## Appeal Decision

**Appeal Ref: APP/R5510/W/25/3362220**

**Upper Floors and Rear of 122-124 High Street, Ruislip HA4 8LS**

- The appeal is made under section 78 of the Town and Country Planning Act 1990 (as amended) against a refusal to grant planning permission.
- The appeal is made by Golds Leisure Ltd against the decision of the Council of the London Borough of Hillingdon.
- The application Ref is 11894/APP/2024/1734.
- The development proposed is the change of use of part of the rear of the building and upper floors from Class E to C3, and new upwards extension to create nine residential dwellings alongside associated works.

Drawing  
**PROPOSED  
 FIRST AND SECOND FLOOR  
 PLANS**

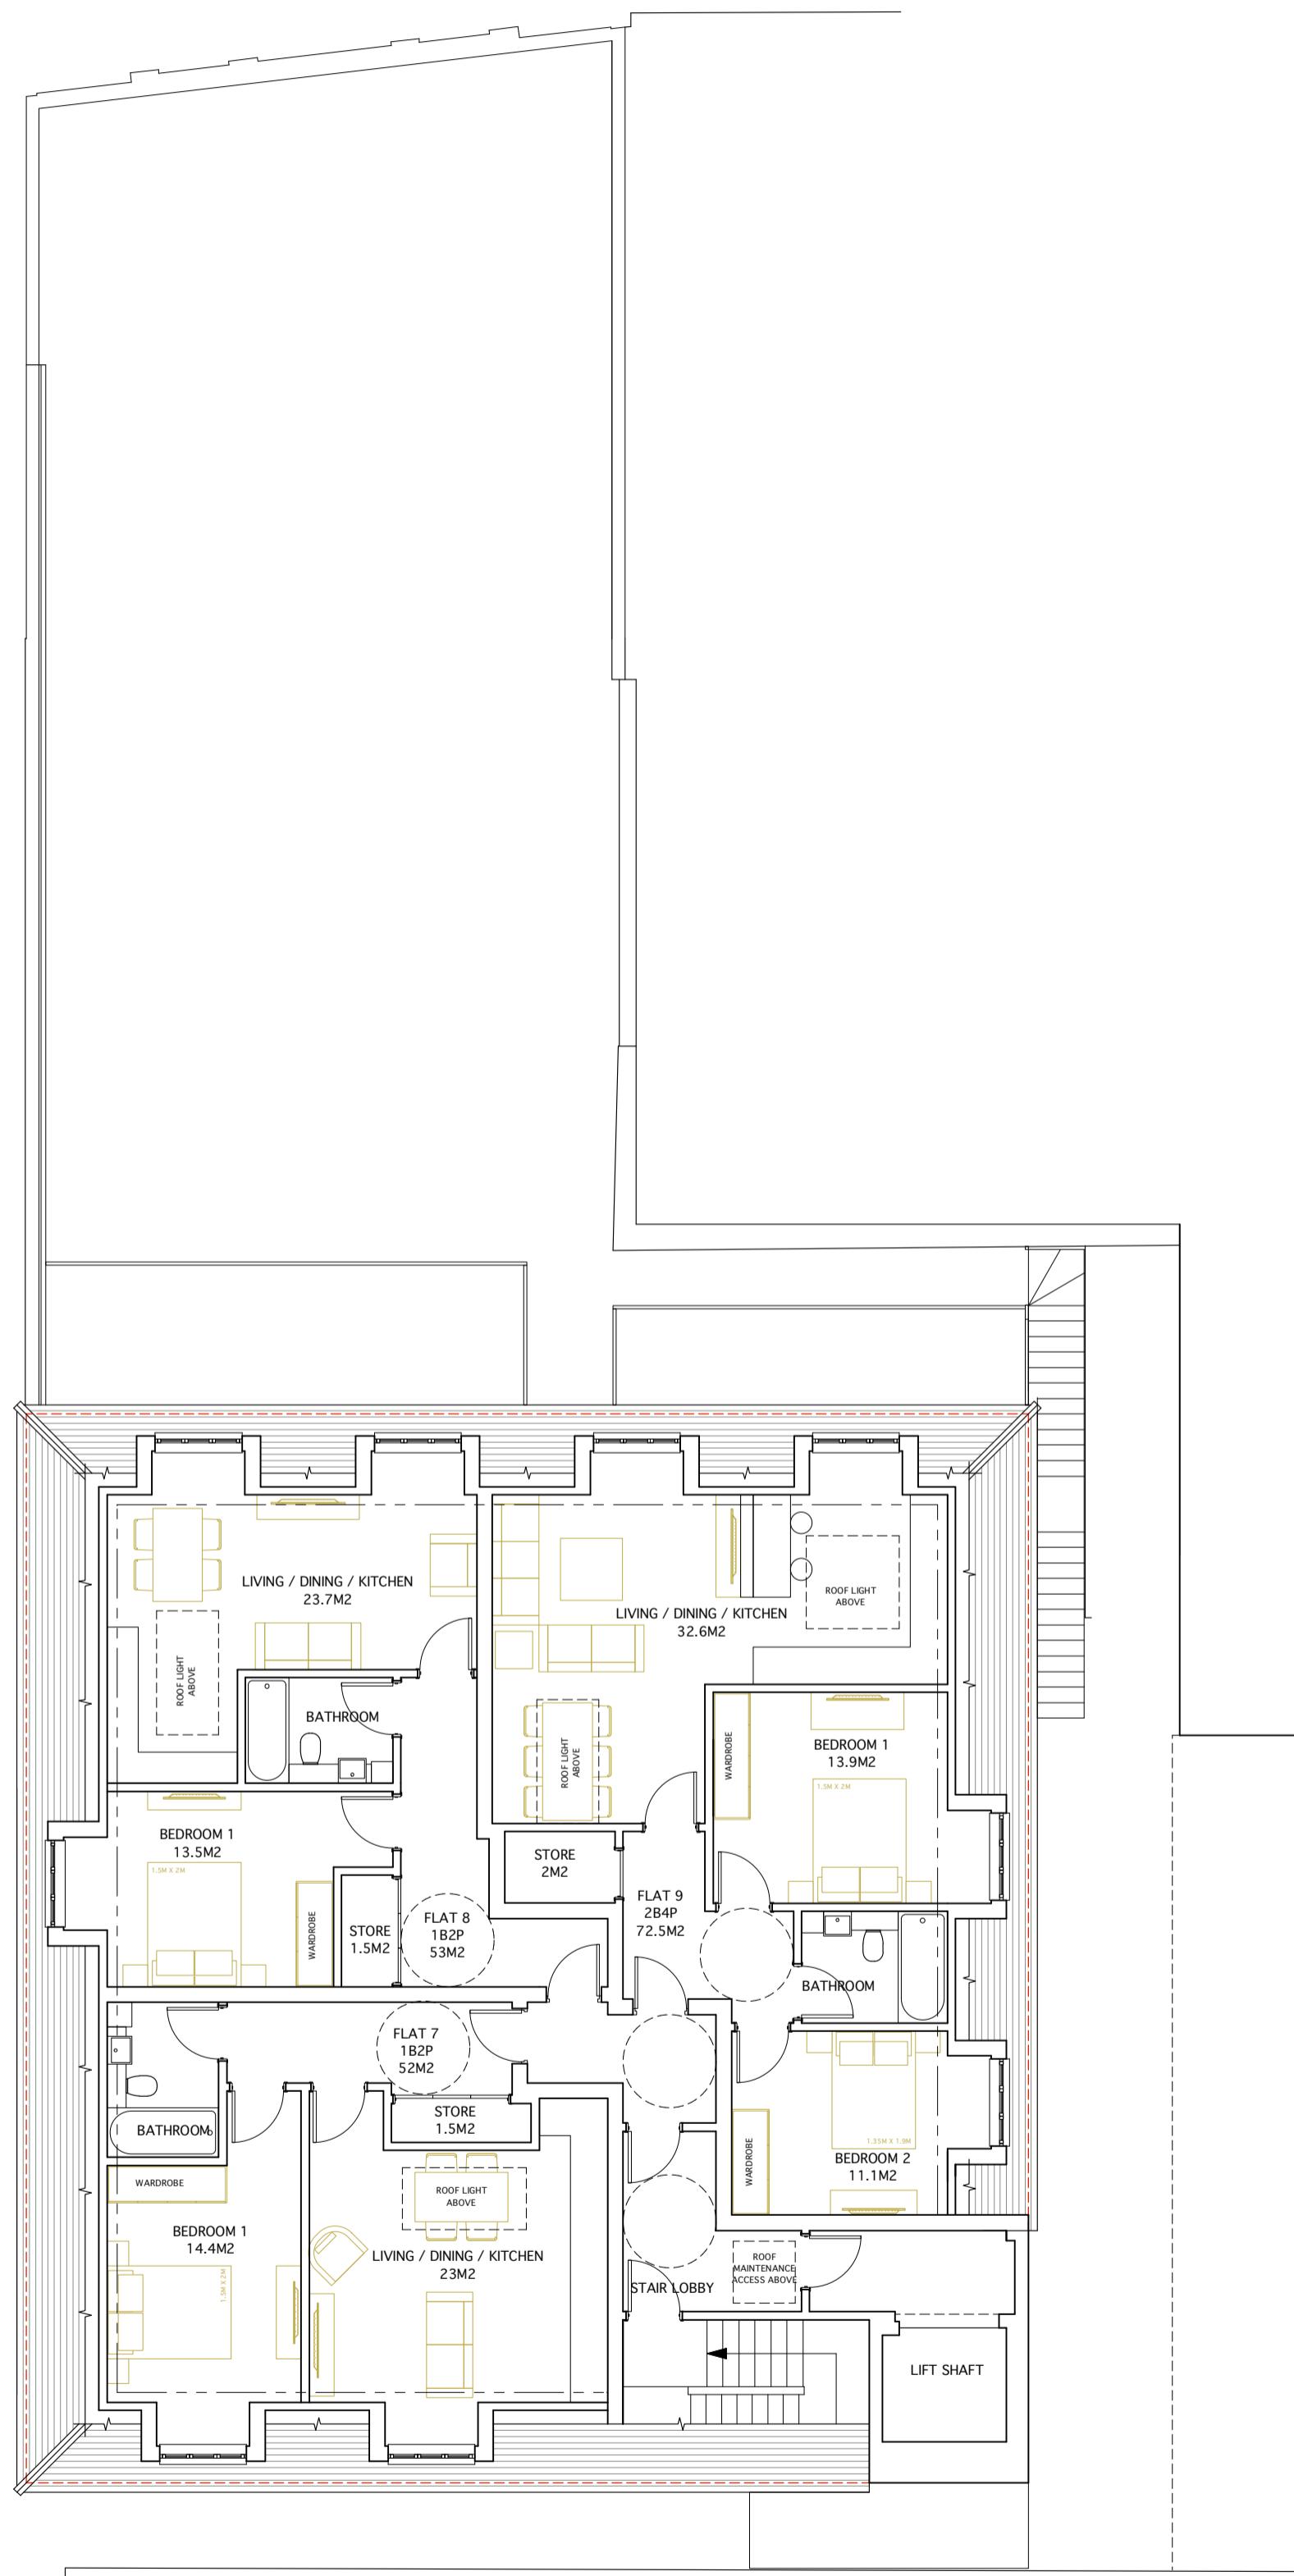
22. Flats 1 and 4 have partial aspect to the north, toward 120a High Street. The outlook from the rooms facing this direction is unlikely to offer a particularly inspiring view however there would be a reasonable outlook with opportunity for natural ventilation. Although these windows face north, these flats are set on a corner, therefore other outlooks would be available to the occupants. Accordingly, I find that these flats would afford the future occupants an acceptable standard of living conditions.

23. Flats 2 and 3 have small outdoor amenity areas and both these areas are below the standards outlined in Table 5.3 of the HLPDMP. The remaining flats within the building have no direct access to any outdoor amenity space. However, the proposal does provide a 176 square metre rooftop outdoor area although this falls below the expected standard of 215 square metres. This outdoor area would be fairly exposed, even with the glazed screens which are proposed as part of the scheme. It would also not be landscaped in a conventional manner, owing to its rooftop location.

25. The screens to flats 2 and 3 would impinge upon the outlook for the residents of these units. However, this provides these residents with a degree of privacy from the communal amenity area and the main entrance into the building. Therefore,

Drawing  
PROPOSED  
ELEVATIONS

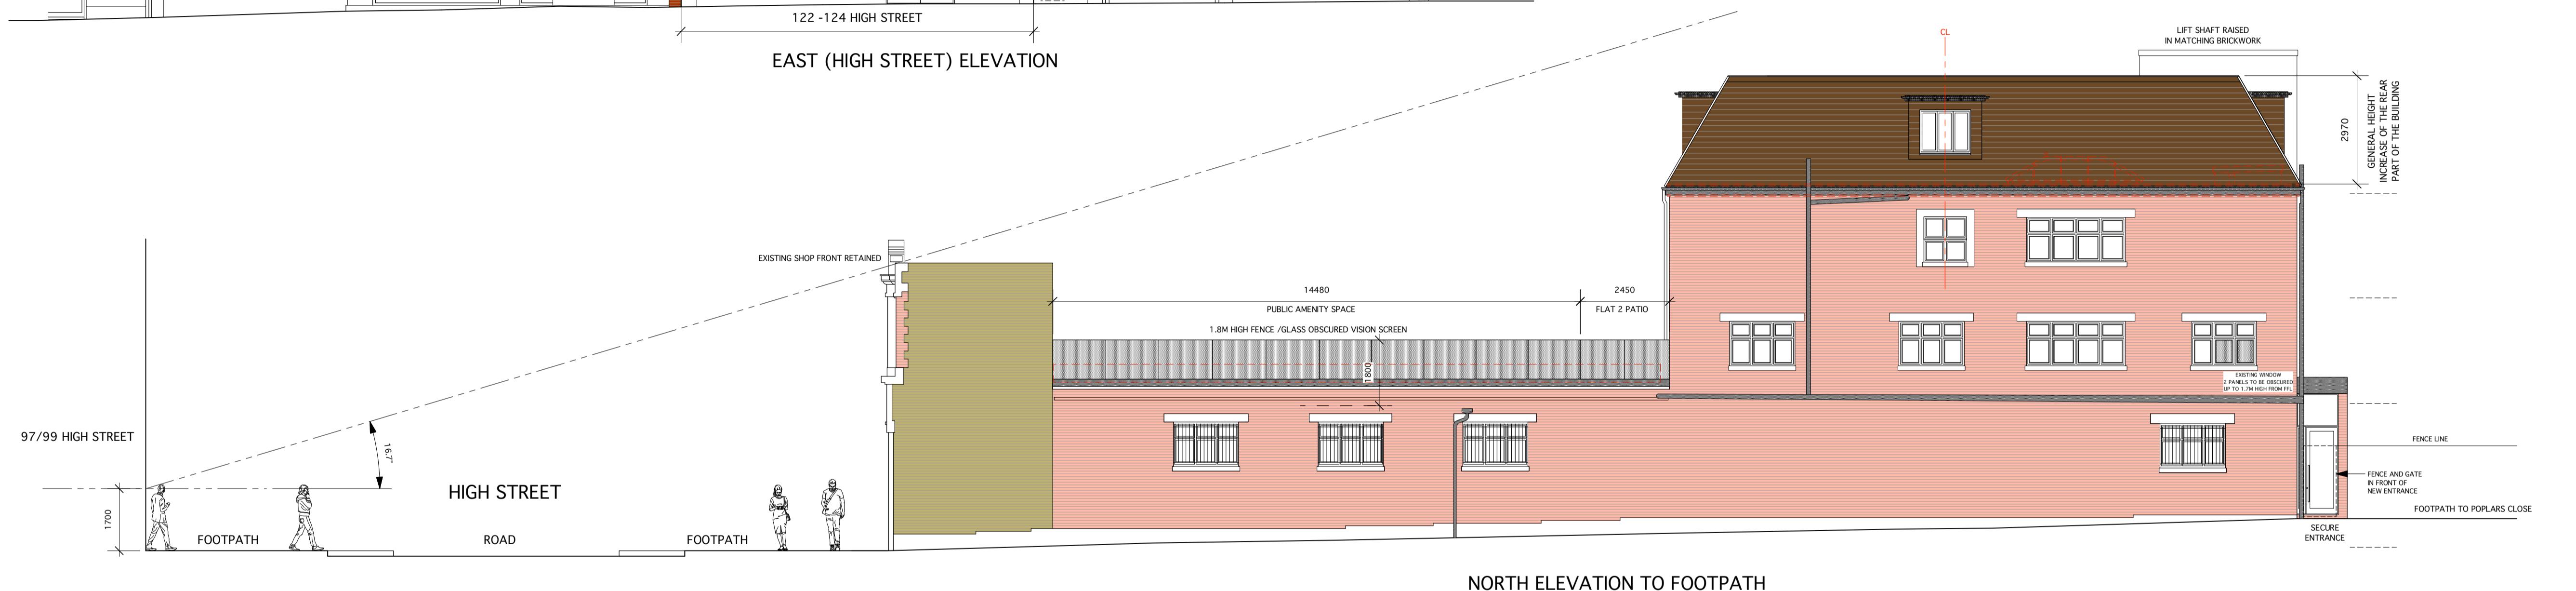
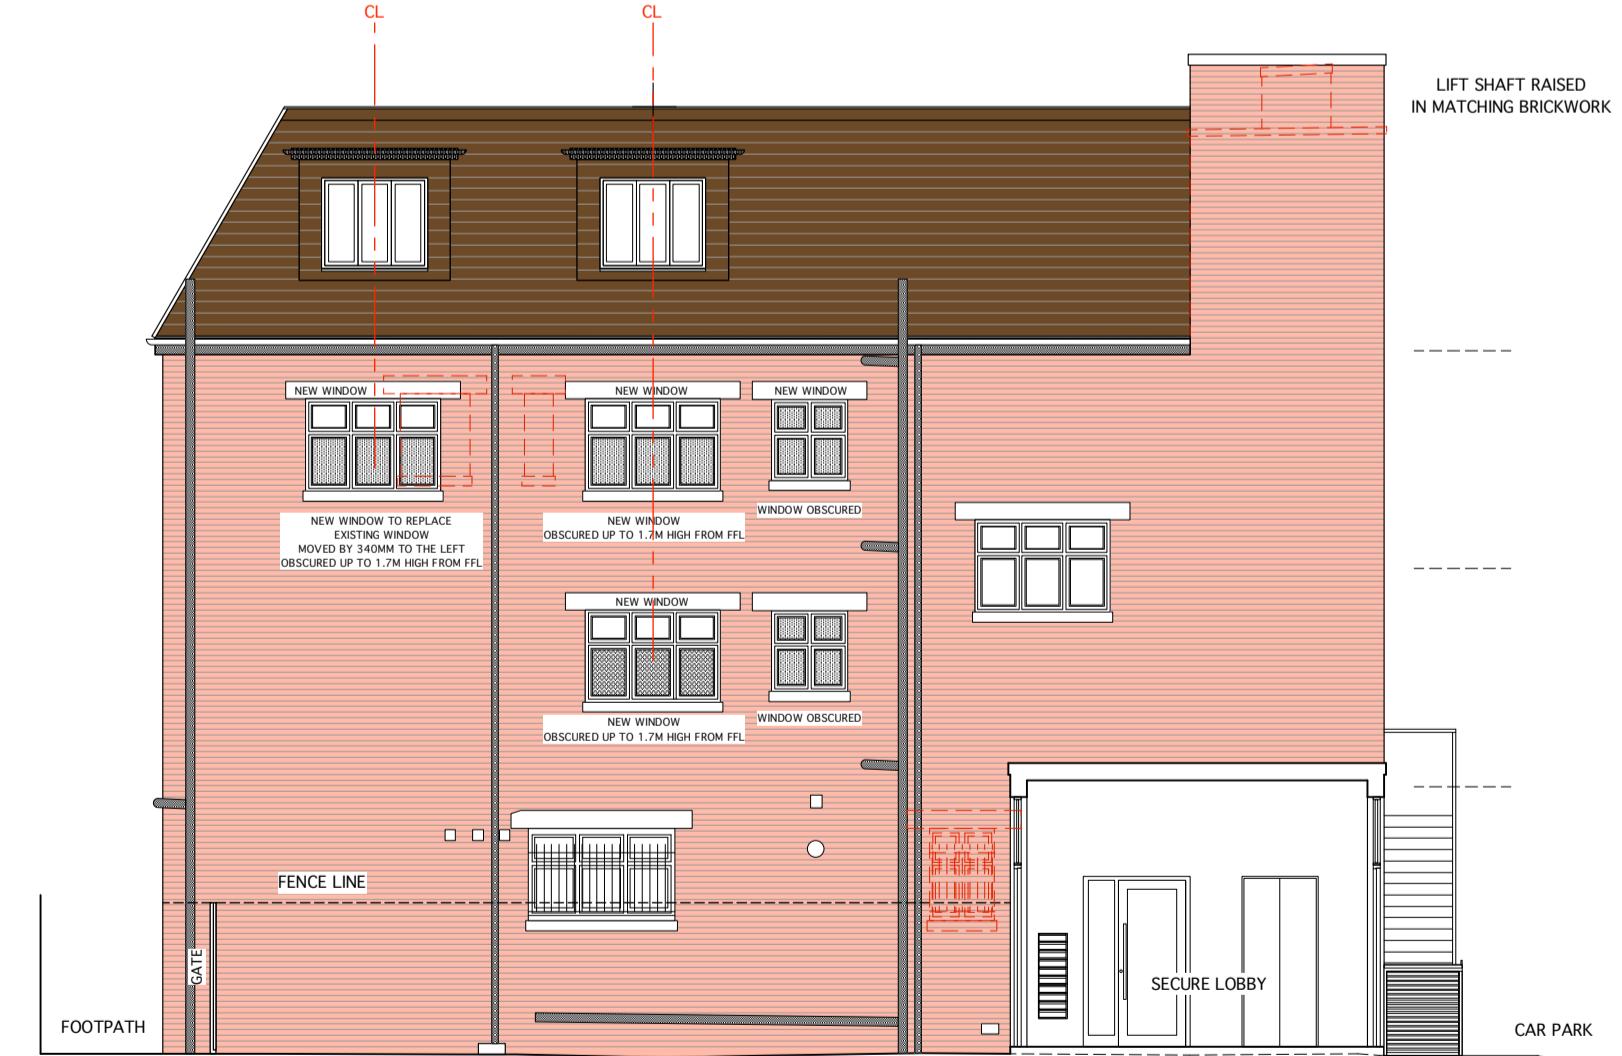
5. The proposal comprises the remodelling of this rear element together with its increase in height to accommodate an additional storey. This would be in the form of a mansard and crown roof with dormer windows inserted to all elevations. The already large and bulky element of the building would therefore be enlarged and increase its prominence within the RVCA. Although this would be unlikely to be discernible from most, if any, aspects from the High Street, it would remain a highly prominent feature when viewed from the rear. This is especially the case along Poplars Close where the already large structure would loom over the much more diminutive, mainly one and two storey homes in this cul-de-sac.

6. The use of the mansard design with dormer windows would, further, appear as a pastiche imitation of the Arts and Crafts design features in the area. The scale and form of the roof structure as proposed would not respect the scale and proportions of this otherwise traditional roof form. I do accept that this would soften the blocky appearance of this element of the building as it appears at present. Even so, the increase in bulk and height would offset this moderate enhancement.

7. I have had regard to the other examples of dormer windows in the area. Numbers 156 and 127 High Street demonstrate clear differences in proportions to this proposal with much smaller dormer windows relative to the roof size. I accept some similarities with the dormers at 73 and 74 High Street, and even the much more modern 61 High Street. However, my main concern here rests with the overall increase in height and dominance of the building and the dormer windows are only one element of the design features here.

8. A such, I find that the roof extension would fail to preserve or enhance the character or appearance of the RVCA. It would cause moderate detriment to the area through its increase in height, bulk and form and cause less than substantial harm to the heritage asset.
